Planning Inspectorate

Acceptance of Applications Checklist

16 October 2026

Lighthouse Green Fuels Project - Section 55 Acceptance of Applications Checklist

Drawing Title
**Figure 10.2
International Statutory Designated Sites
within 20km**

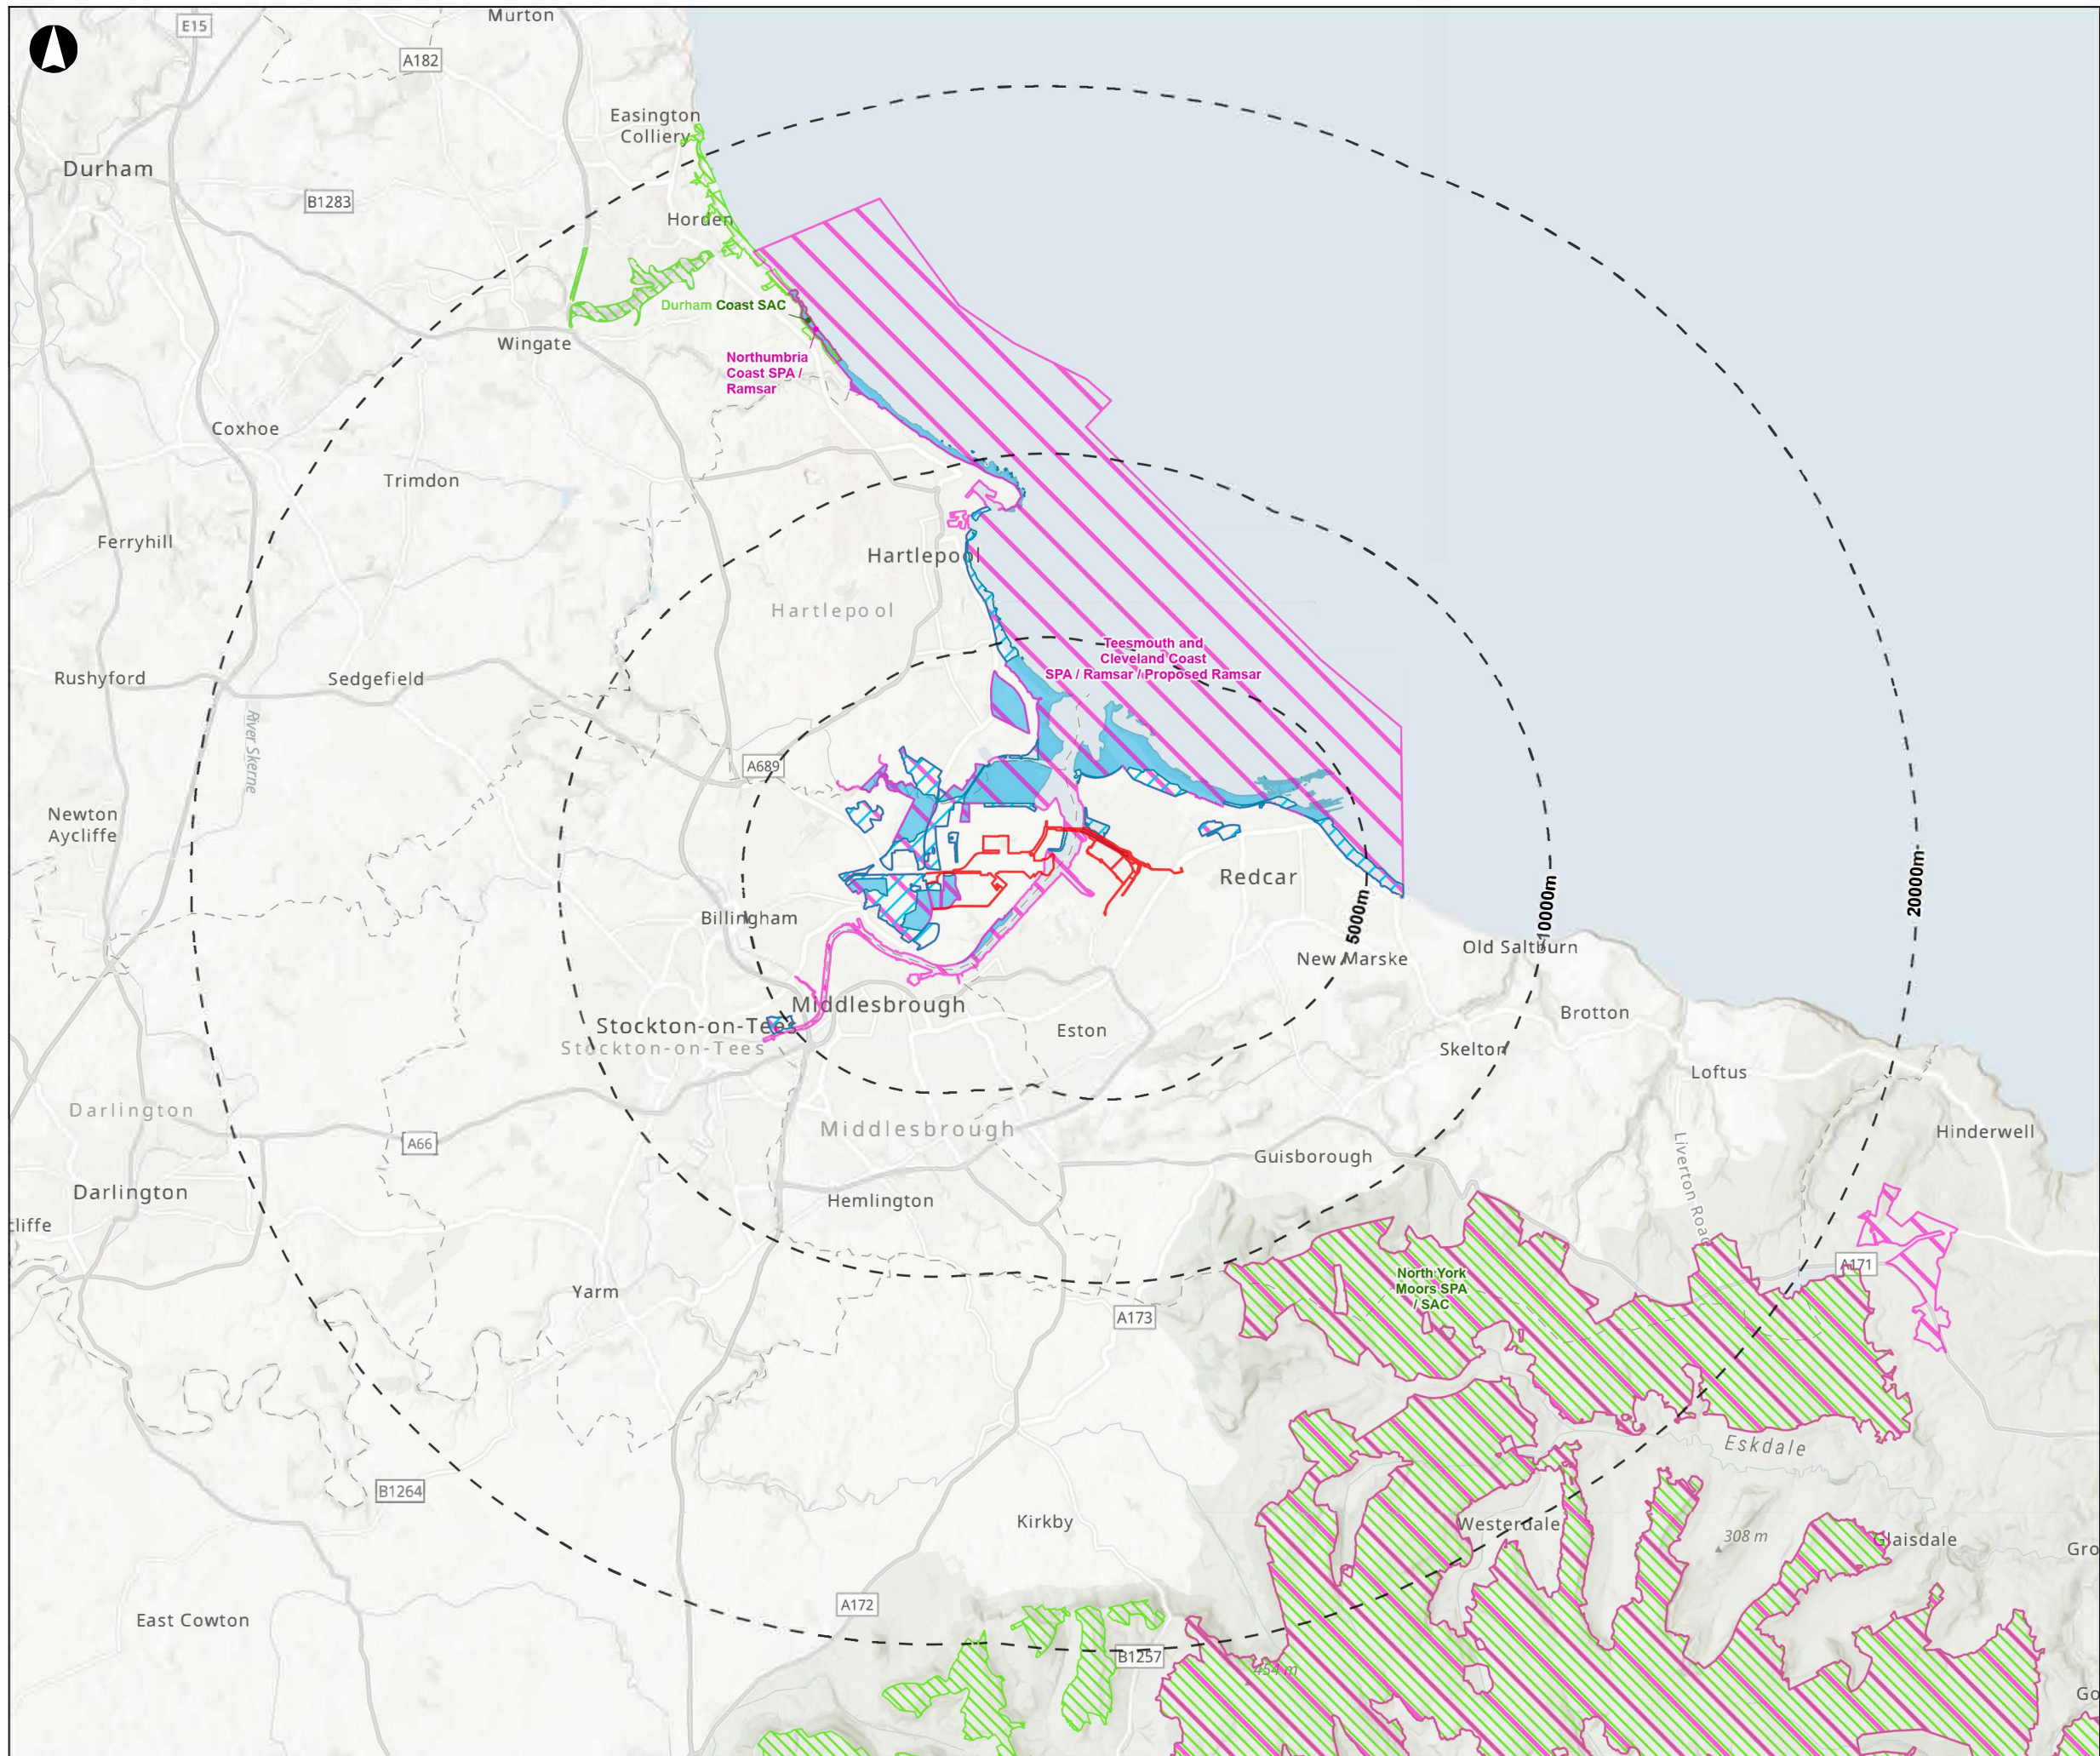
- **Chapter 5 Construction Programme and Management Document (Doc 6.1.5)** contains track changes that have not been accepted.
- **International Statutory Designated Sites within (Doc 6.2.32), figure 10.2** does not label Castle Eden Dene Special Area of Conservation (SAC).
- **National Statutory Designated Sites within 20km (Doc 6.2.33), figure 10.3** does not label Durham Coast Site of Special Scientific Interest (SSSI) and incorrectly labels Castle Eden Dene SSSI.

- **Report to Inform Habitat Regulations Assessment (Confidential) (Doc 5.11.2)** - Annex A: Figure 10.2 International Statutory Designated Sites within 20km does not label Castle Eden Dene SAC.
